WEST SUSSEX COUNTY COUNCIL CONSULTATION

TO:	<u>Arun</u> District Council FAO:Raymond <u>Coles</u>
FROM:	WSCC - Highways Authority
DATE:	7 April 2021
LOCATION:	Land West of Hook Lane and South of <u>Sefter</u> Road <u>Pagham</u>
SUBJECT:	<u>P/50/21/PL</u> Change of Use of Agricultural Land to Public Open Space. This application is a Departure from the Development Plan and is within Strategic Site SD2, CIL Zone 1 (Zero Rated).
DATE OF SITE VISIT:	<u>n/a</u>
RECOMMENDATION:	No Objection
S106 CONTRIBUTION TOTAL:	<u>n/a</u>

Location and Block Plan

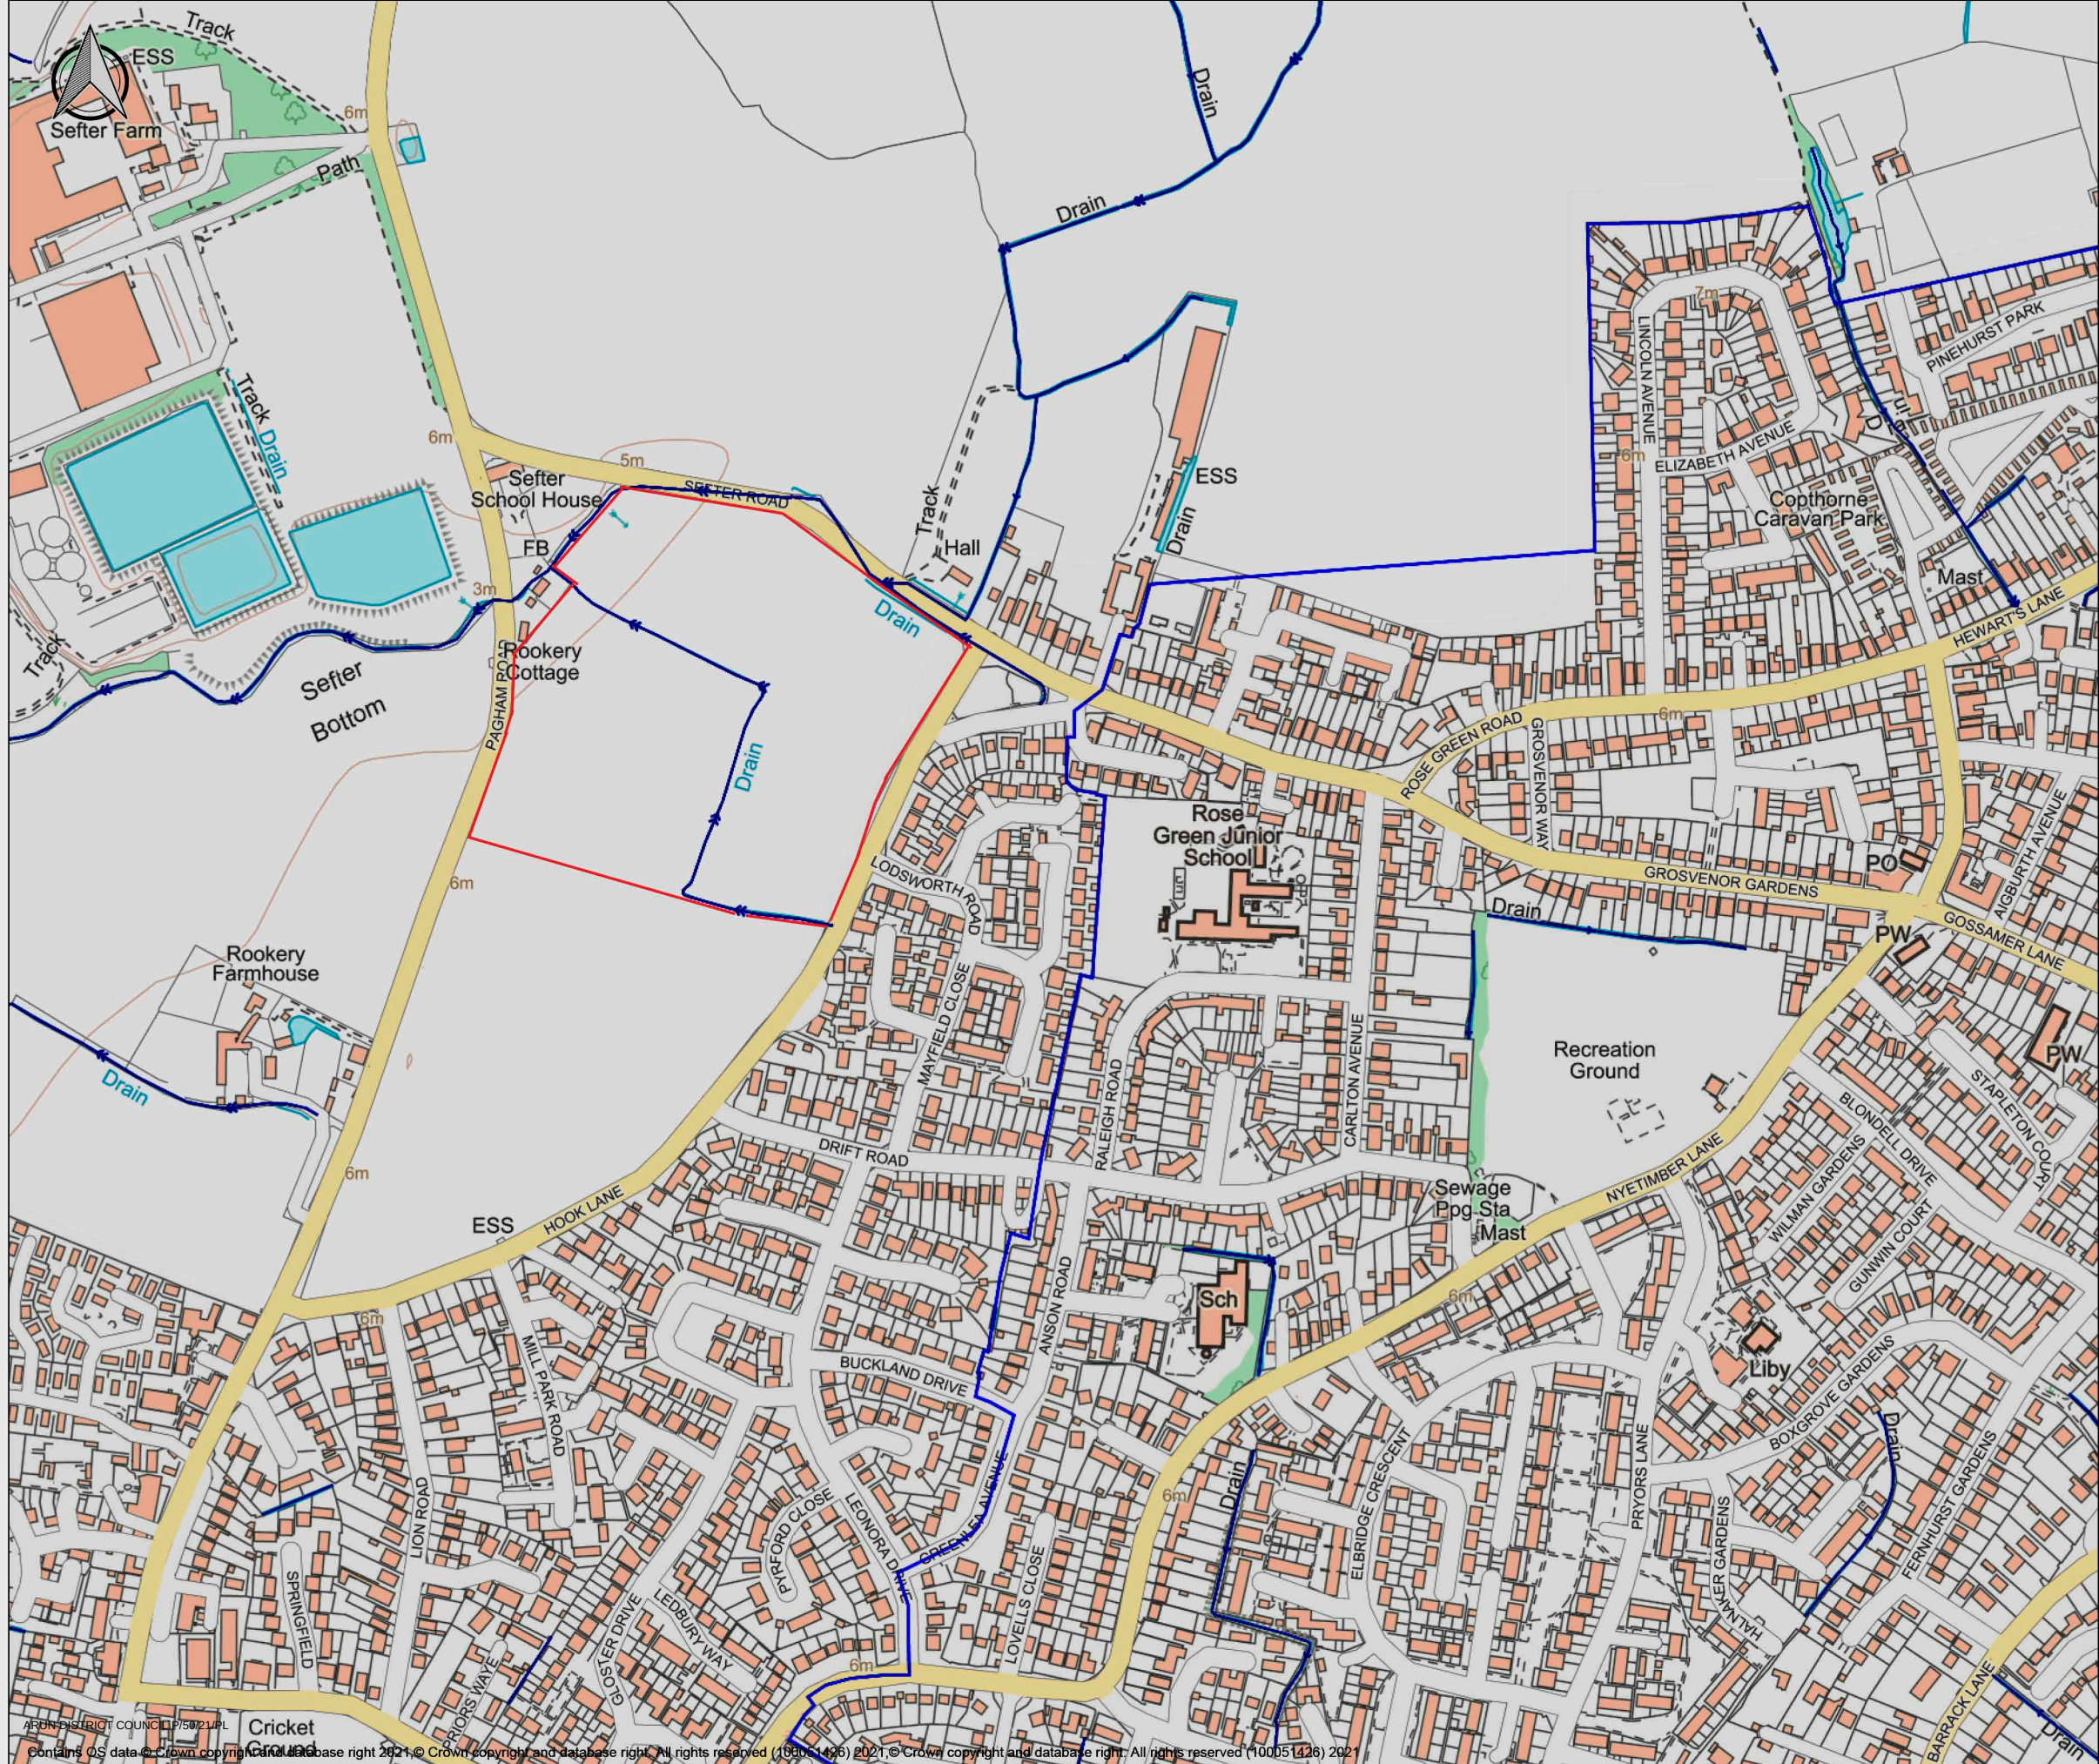
The supporting statement indicates no changes are proposed to existing accesses on Sefter Road, Hook Lane, and Pagham Road. It would however appear that there are only existing vehicular accesses onto Sefter Road and Pagham Road with there being no access onto Hook Lane. These are expected to be used only to enable vehicles to access the land for maintenance purposes as no car parking for visitors is indicated.

Given the land is proposed to be used for public recreation, suitable pedestrian access would need to be achieved. Given the lack of footways on Sefter Road and Pagham Road, access would be required from Hook Lane where footways are present. There appear no substantial constraints to prevent pedestrian access onto Hook Lane. Details of access for pedestrians from Hook Lane should therefore be secured via condition. Wording is suggested below.

Prior to the use of the land for public recreational purposes commencing, access for pedestrians shall be provided to the land from Hook Lane in accordance with plans and details submitted to and approved in writing by the Local Planning Authority.
